FAO: Planning Department,  
Welwyn Hatfield Borough Council

Ref: 6/2019/0918/HOUSE  
Date: 10/05/2019

## HISTORIC BUILDINGS AND CONSERVATION ADVICE

**RE: *Northaw Place, Coopers Lane, Northaw***

Drg. No
747 / SP3

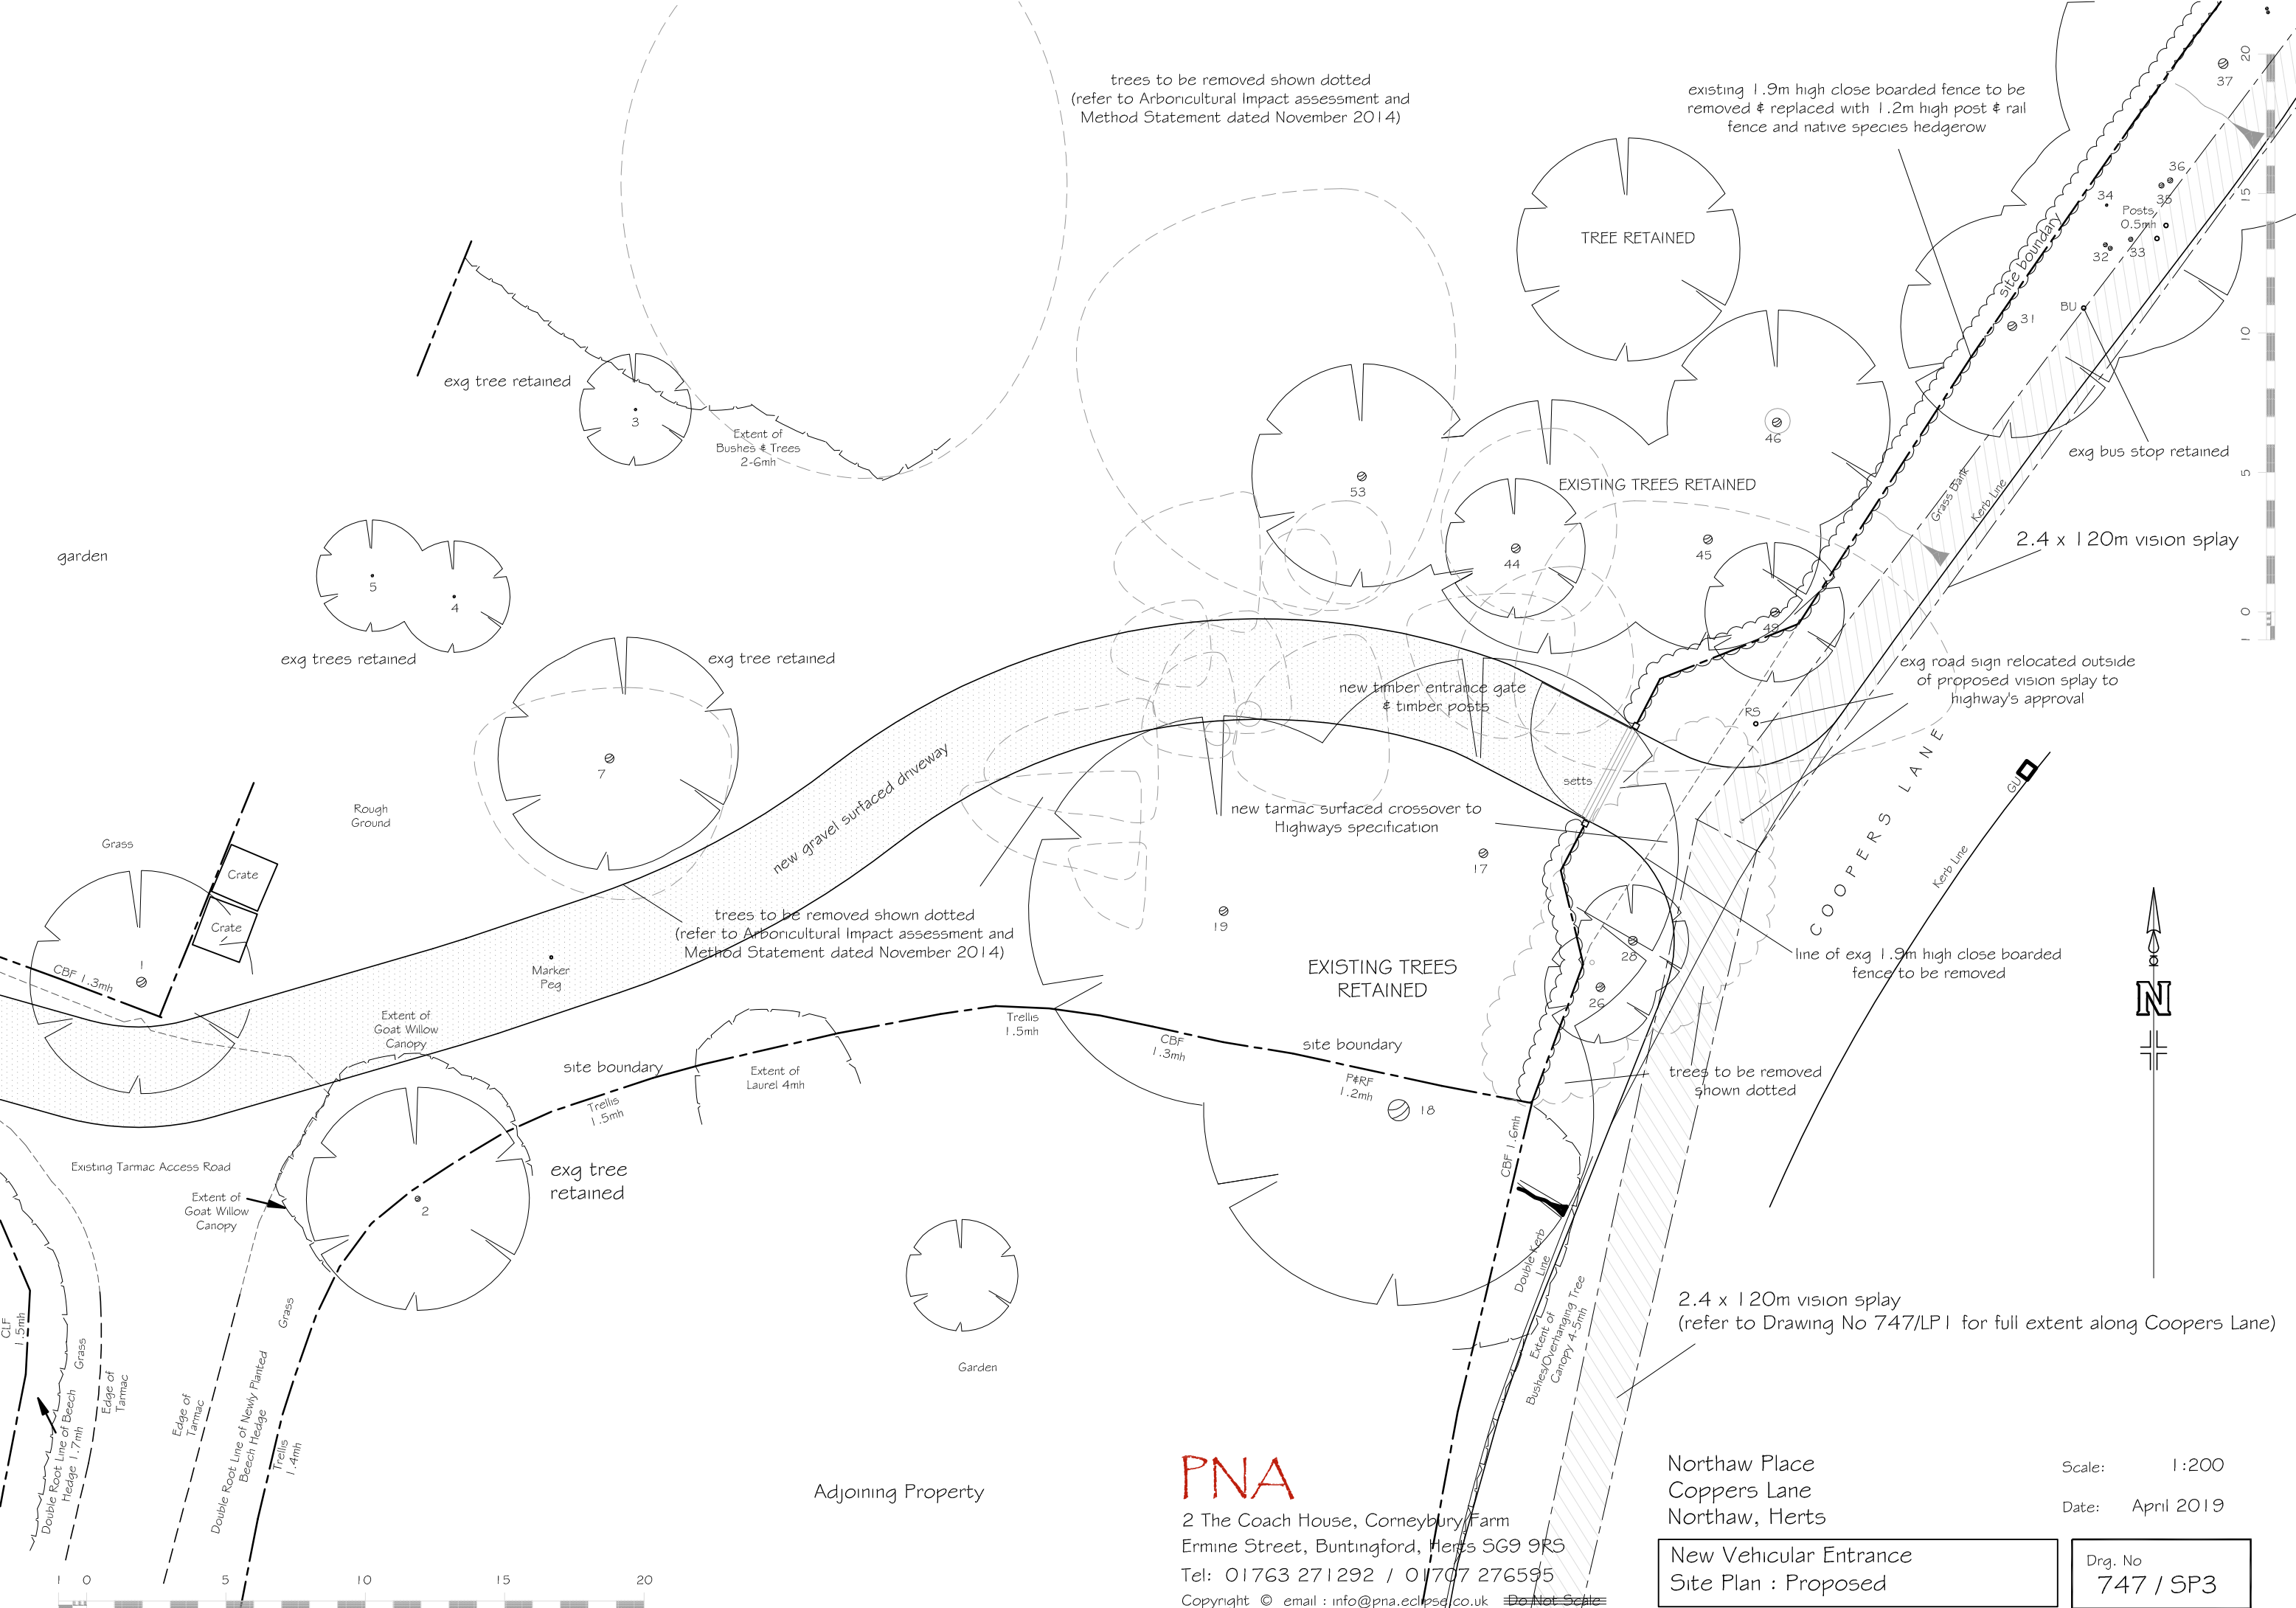
The boundary along Coopers Lane will be finished with a timber post and rail fence with native hedging and a timber five-bar gate. This maintains the rural appearance of the lane which is characterised by dense planting. The simple fence and gate do not compete with the existing entrance to Northaw Place which has a far more formal character with brick piers and gates.

The proposed access, driveway and boundary treatment are considered to be in keeping with the setting of the listed building and will not harm its significance. The reinstatement of the historic line of the driveway (or close to) serves to enhance the significance of the house by revealing historic viewpoints of the principal elevation of the house.

No objections are raised to the granting of planning permission and it is recommended that a condition requires photographic details of the new gravel hardstanding of the driveway to be submitted and approved.
